Our ref: PS123790-TPD-LTR-002 RevB

Kellyville Park Redevelopment – Response to TfNSW Comments

Following the delivery of the Traffic Impact Assessment Report (PS123790-TPD-REP-001 RevF prepared by WSP dated 16/03/22) it is understood that Transport for New South Wales (TfNSW) has undertaken a review of the proposal and have provided comments within their advice letter dated 25 May 2022 (TfNSW Reference: SYD21/00890/02) a copy of which is included in Attachment A to this letter.

Figure 5.1 Anticipated Traffic Distributions

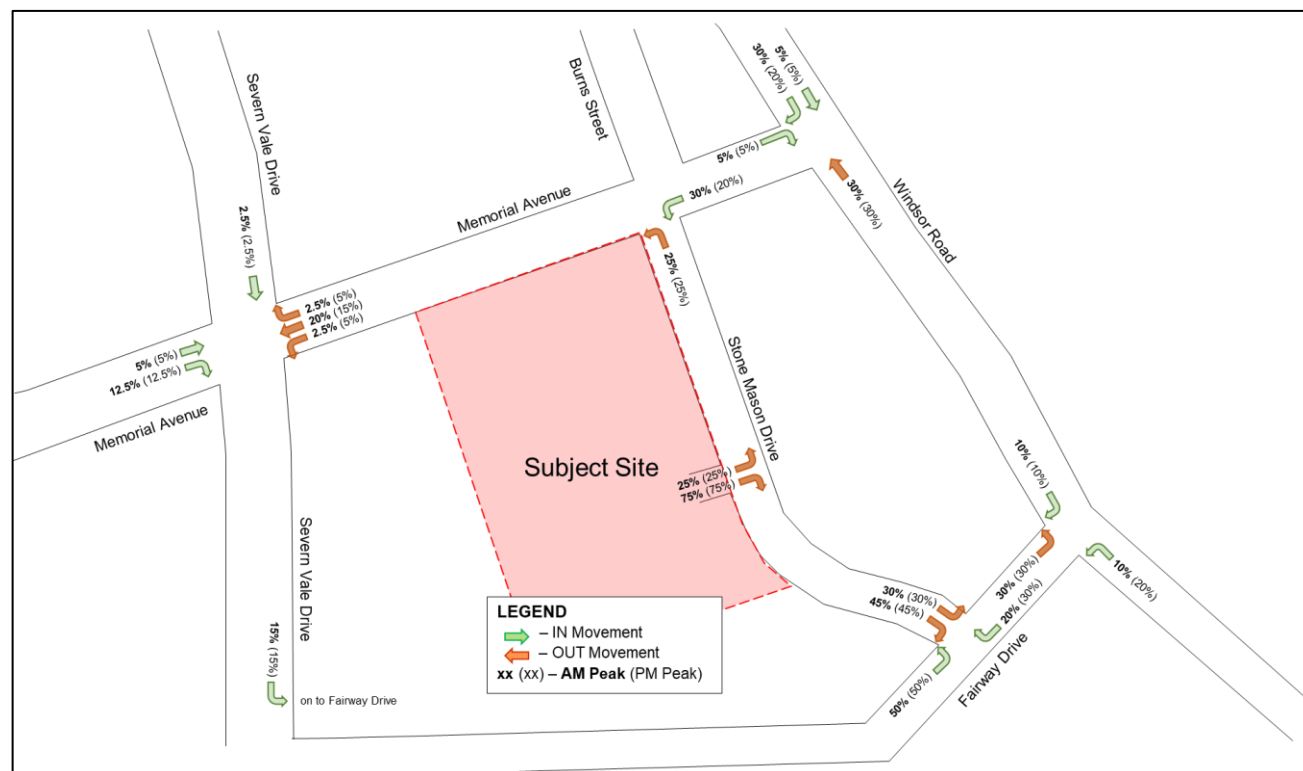
ITEM 5	
TfNSW	TfNSW requests the proponent clarify the U-turn movement at Memorial Rd/Windsor Road intersection (see Figures 5.1 and 5.2 in the Traffic Impact Assessment Report). U-turn movements at signalised intersections are not permitted in NSW unless signposted otherwise. This movement is not supported and should not be accounted for in determining the traffic distribution to the site

Response	<p>This comment is noted and the relevant diagrams (Figures 5.1 and 5.2) have been updated accordingly to remove the U-turn and redistribute the traffic that had previously been associated with this movement.</p> <p>This redistribution of traffic has only resulted in a minor change in traffic volumes at other intersections which has not impacted the outcomes of the undertaken intersection analysis.</p> <p>The SIDRA analysis has been updated to account for this change in traffic volumes.</p>
Report Location	<ul style="list-style-type: none"> — Section 5.3 – Figure 5.1 — Section 5.4 – Figure 5.2 — Section 6

PS126940 SK006
INDICATIVE INBOUND CONSTRUCTION
VEHICLE MOVEMENTS 05
C.H. 17.10.2021

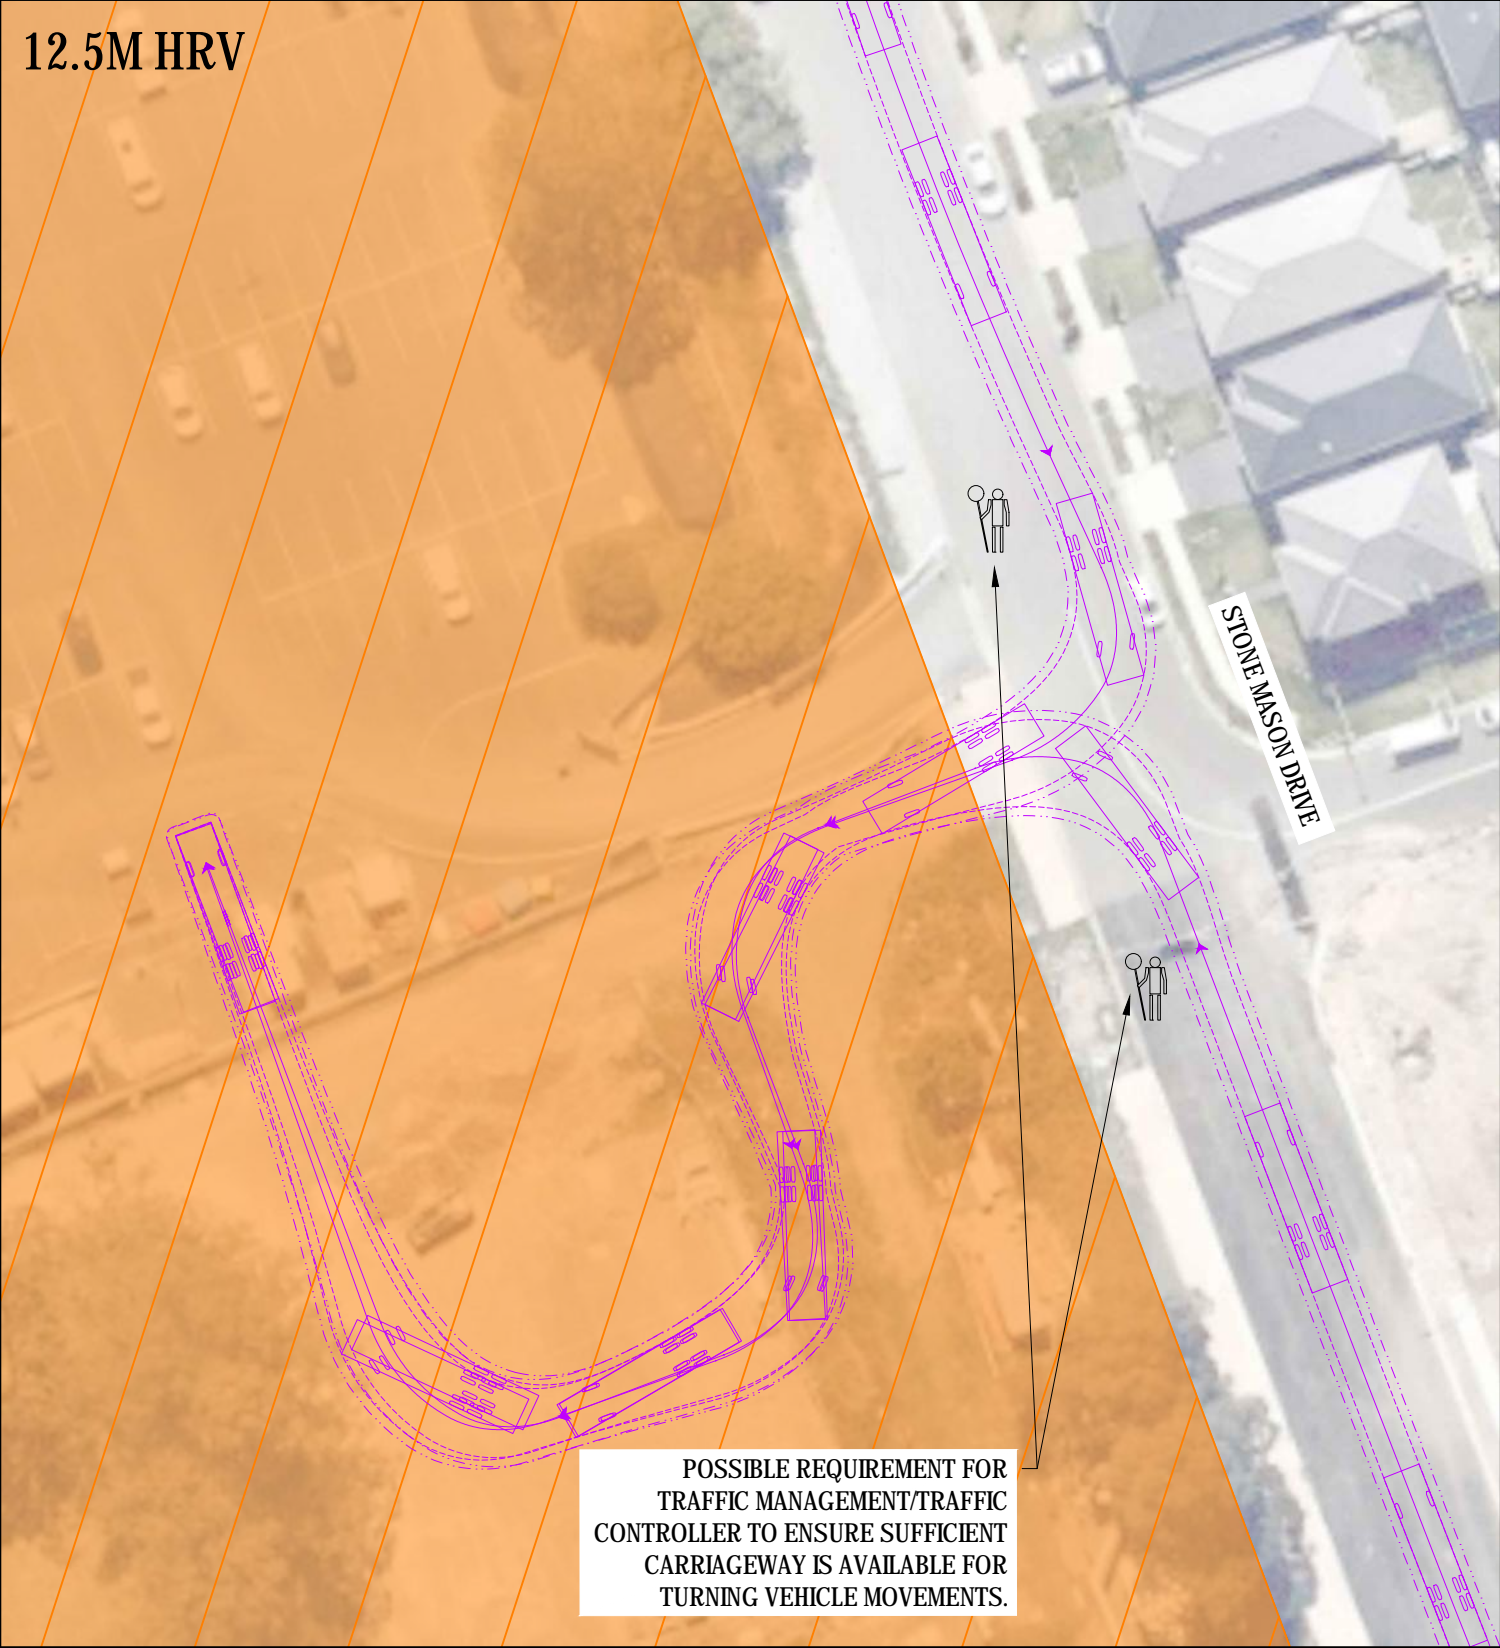
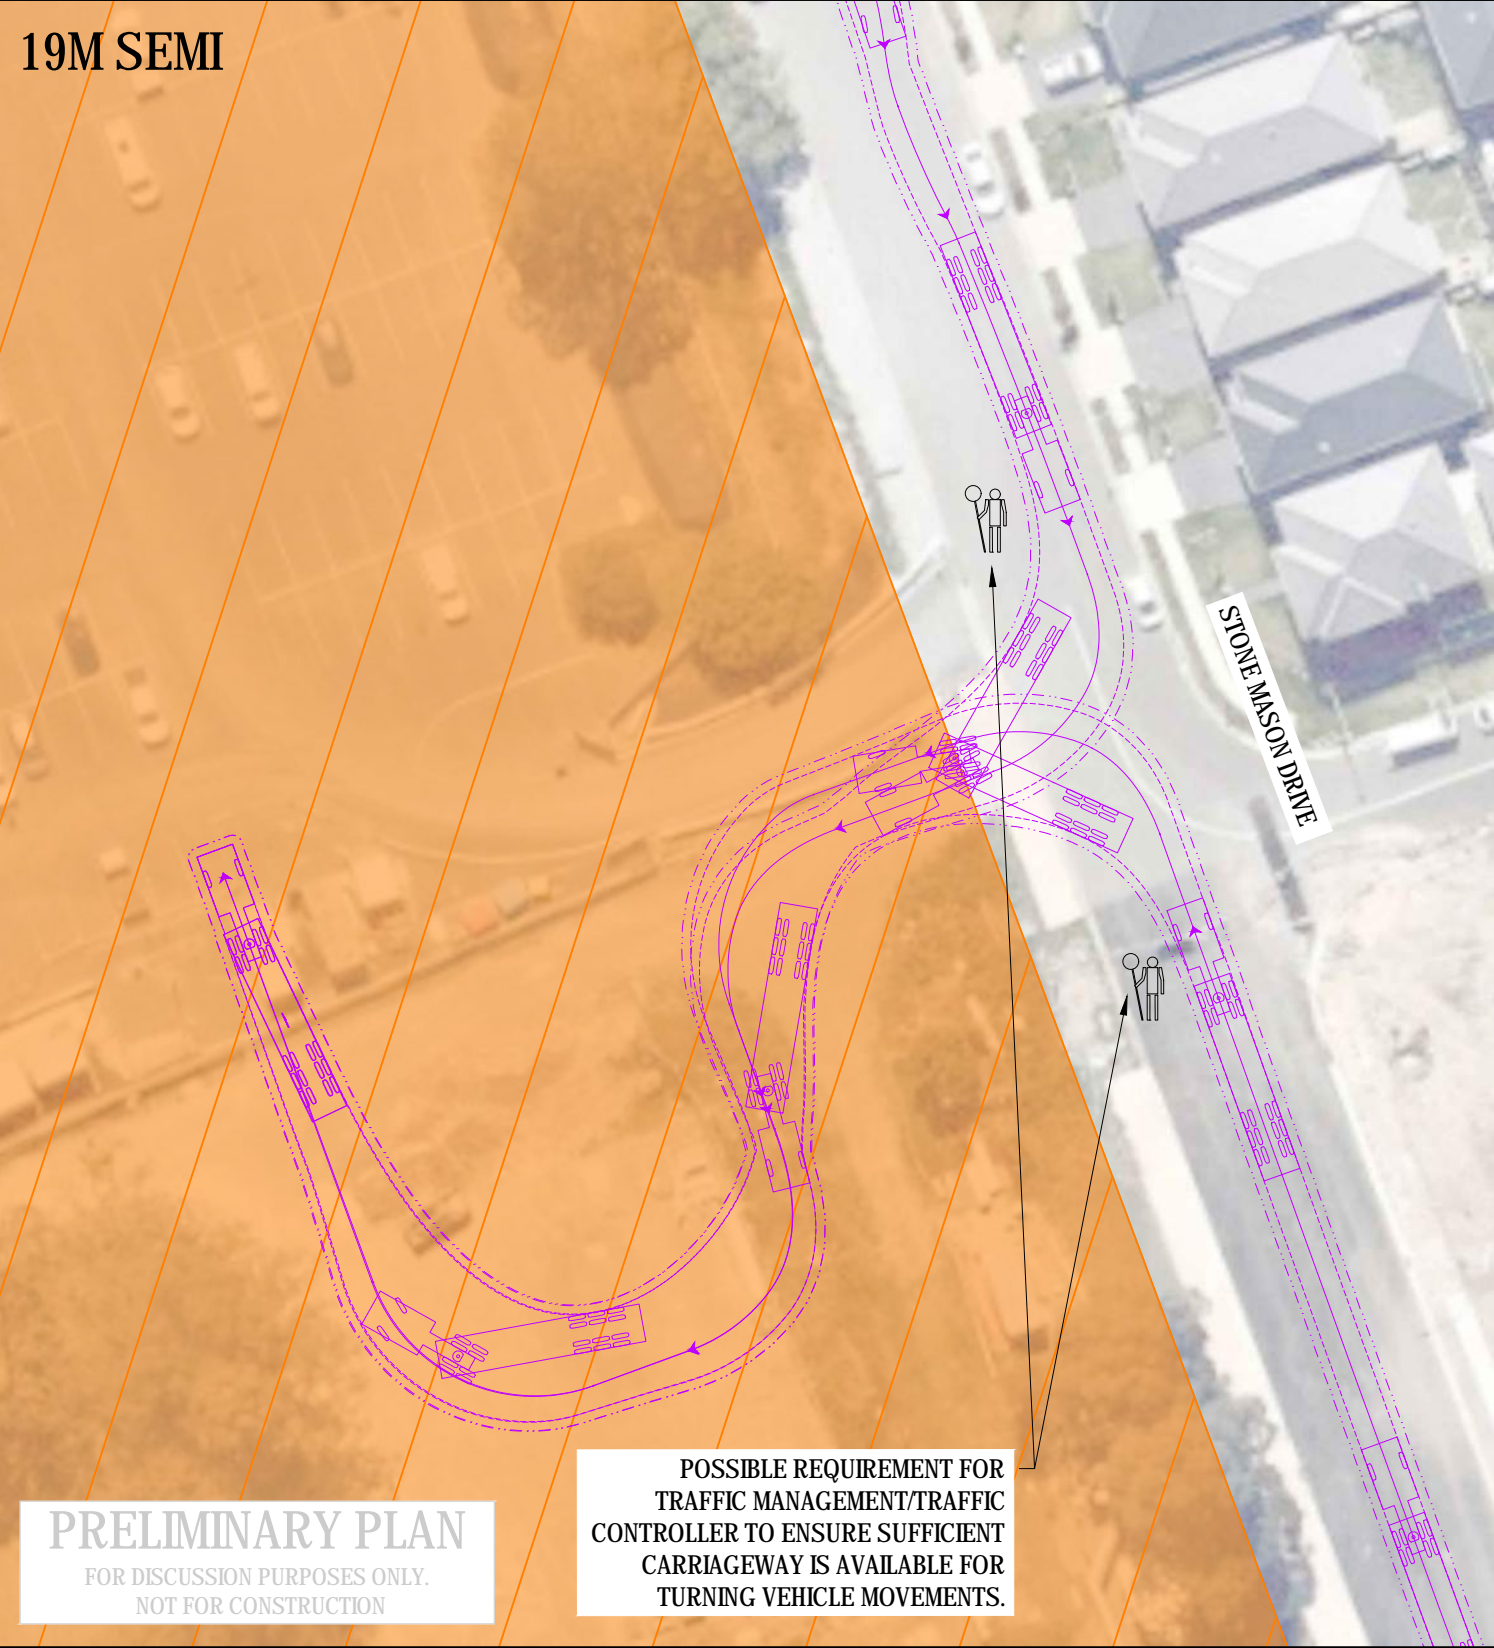
ITEM 6	
TfNSW	The swept paths clearly show requirement for traffic management at Windsor Rd/Fairway Drive and access to Stone Mason Drive (not possible) and possible requirement for Memorial Av/Windsor Rd (19M SEMI and 12.5 HRV). This is a concern and may not be supported.

Response	The swept path diagrams are for construction vehicle movements during the construction stage of works. As noted on the diagrams, it is intended that some form of traffic management would be required during this stage with these details addressed as part of the formal CTMP.
Report Location	<ul style="list-style-type: none"> — Section 9.2 — Appendix F
